ASSESSMENT REPORT

Nadine Street Residential Subdivision, Sanctuary Point DA 485-12-2002 MOD 1

M:\Projects\20000\26522\Drawings\26522-406-TREES RETAINED.dwg

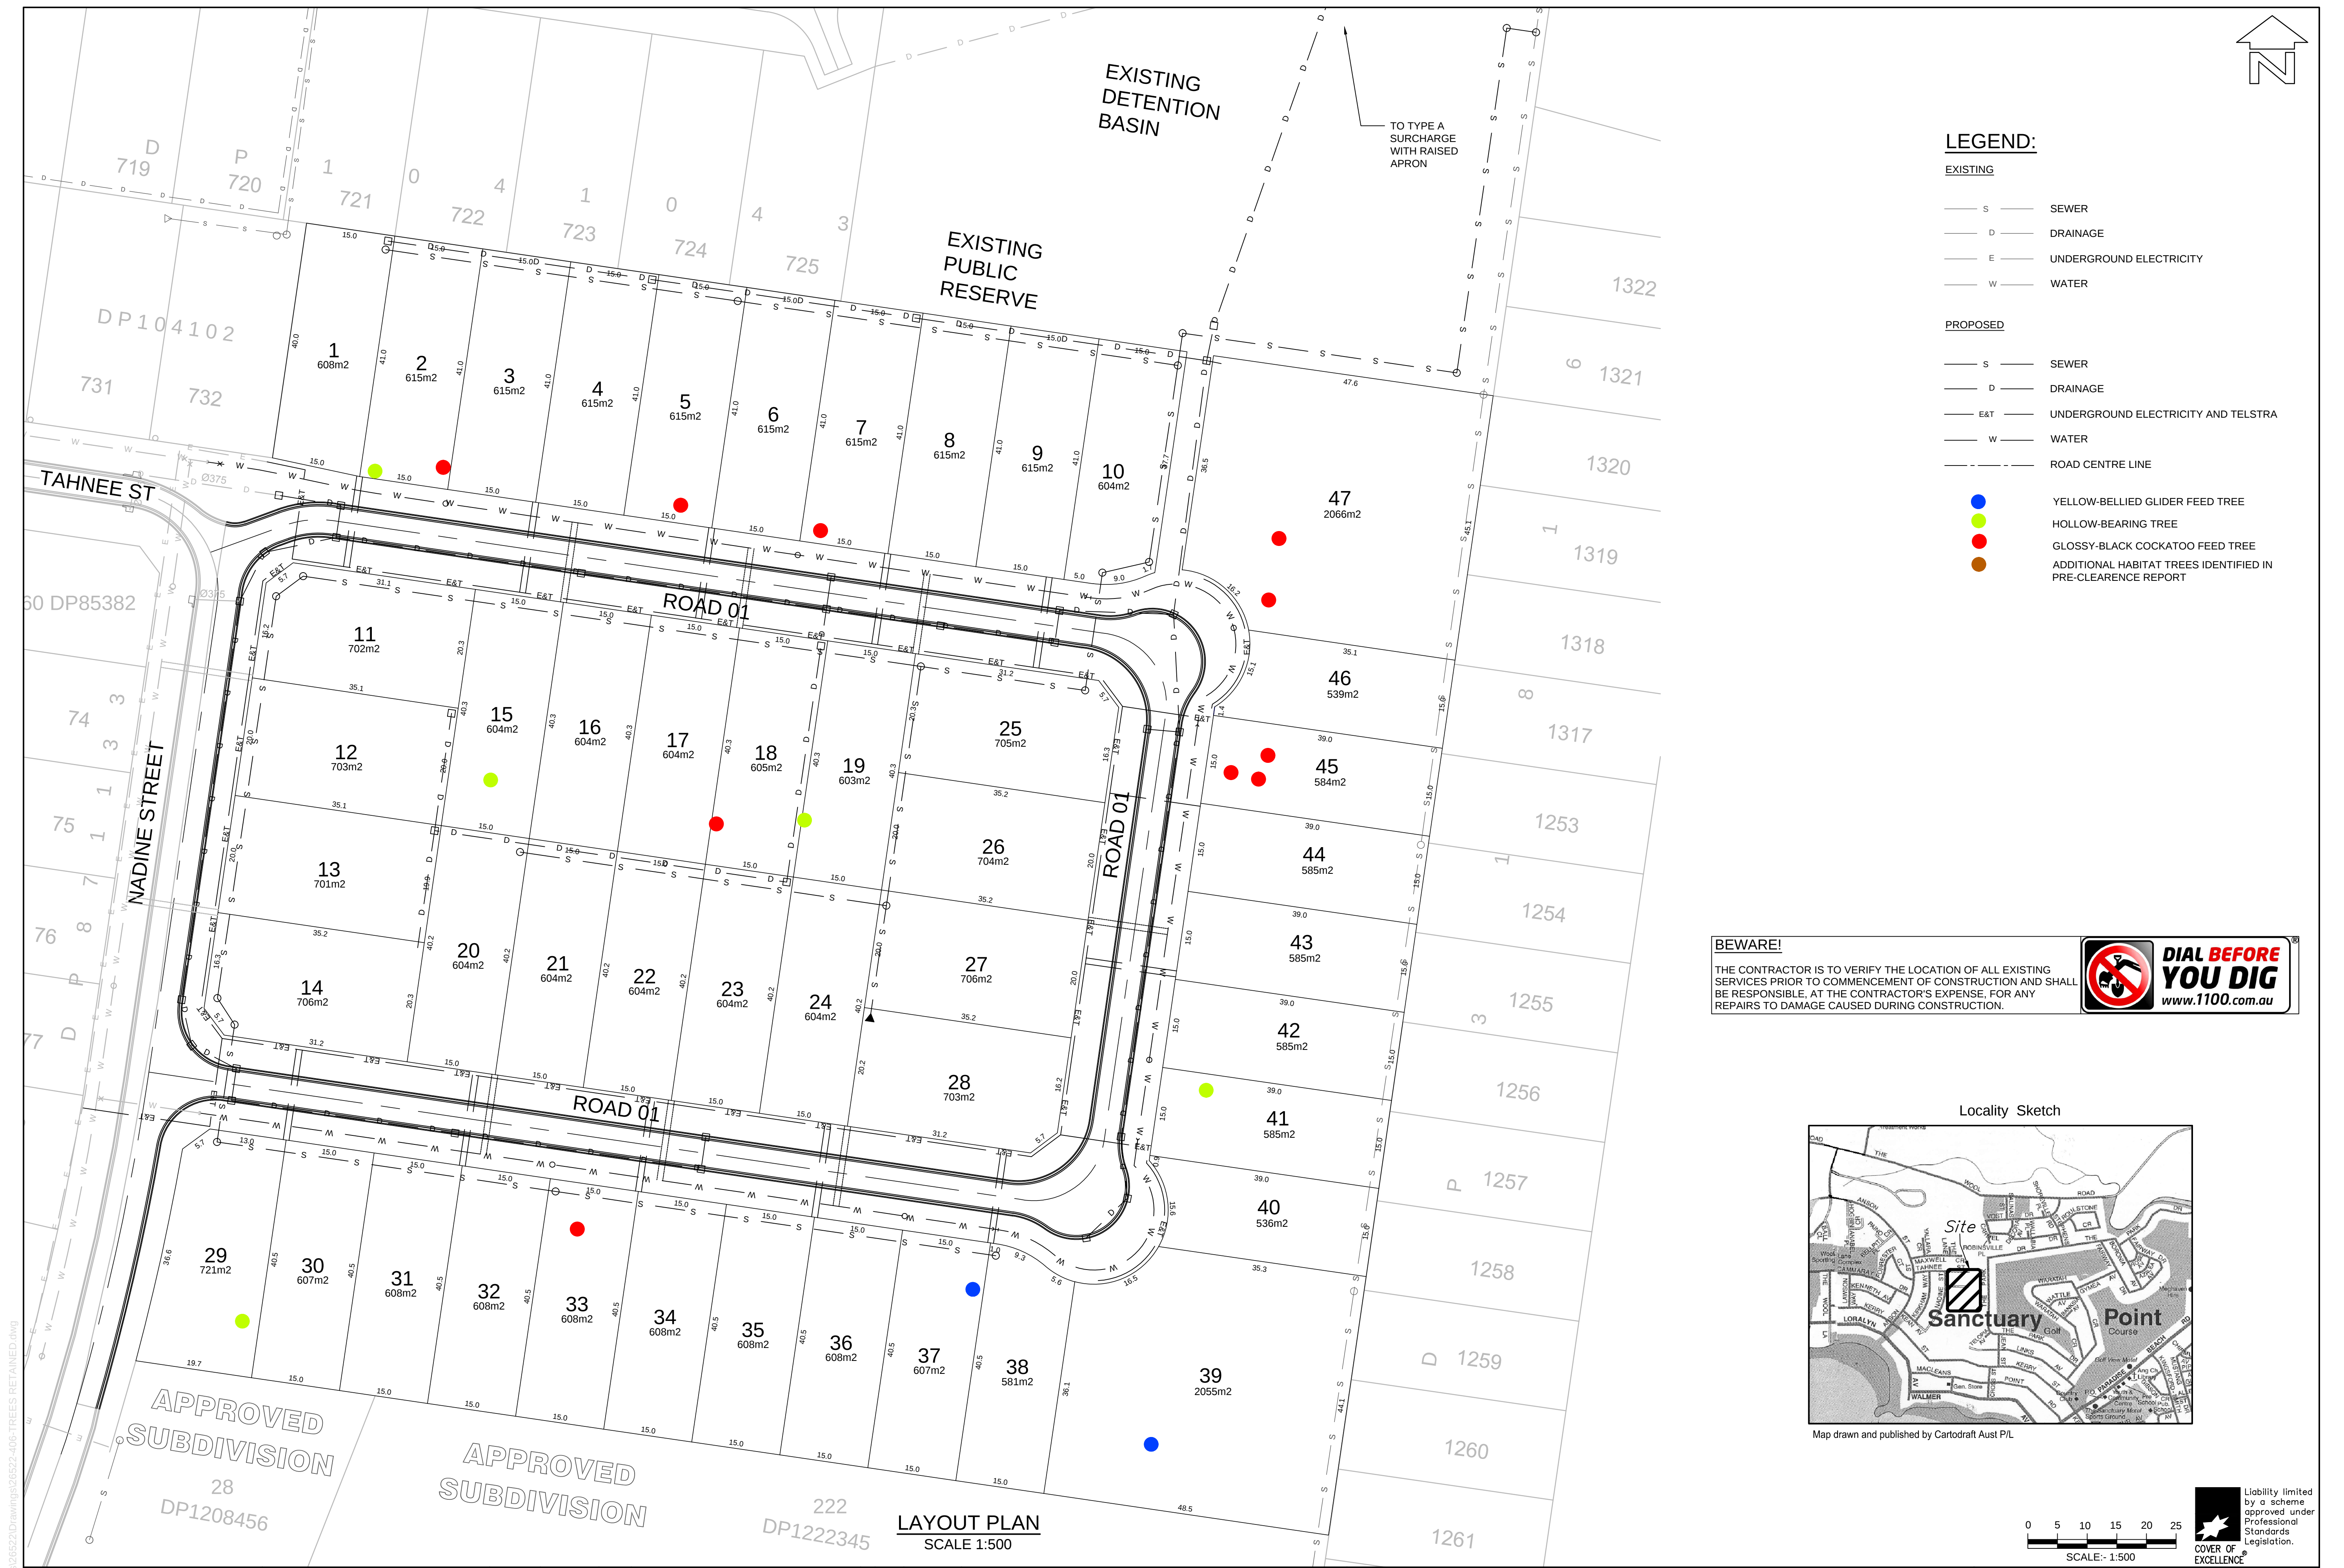
<i>Retained vegetation</i>	- The original DA approved the site to be cleared with the exception of 17 trees of significant biodiversity value required to be retained. - The site has now been cleared of native vegetation in accordance with the original DA. - More than half of the public submissions raised concern about the biodiversity impacts associated with the removal of native vegetation from the site. - Council recommended the impact of the subdivision on remaining vegetation be assessed. - The Proponent has confirmed the proposal does not seek to remove any of the trees to be retained. The Proponent also requested the requirement for a Section 88B Restriction under Condition B4(g) be deleted as SDCP 2014 adequately addresses the protection of trees. - The Department notes the removal of vegetation was considered in detail as part of the assessment of the original DA and this modification application does not propose to remove the trees identified for retention. - The Department notes two of the retained trees (at Lots 18 and 19), are located on, or partly on, the proposed lot boundaries. To ensure these trees are not adversely affected by the revised subdivision (i.e., they are retained as intended), the Department recommends a condition requiring the boundaries be amended to better accommodate these trees. - The Department is satisfied the requirement for the s88 Restriction can be removed, as: the remainder of Condition B4(g) requires trees to be retained, an updated tree retention plan has been provided, (and would form part of the approved drawings), and Council would be required to consider any request to remove trees as part of future DAs or tree removal applications.	The Department has recommended a new Condition B10 (b) requiring the amendment of the boundaries of Lots 18 and 19 to better accommodate retained trees. Condition B4(g) is updated to remove the requirement for a s88 Restriction.
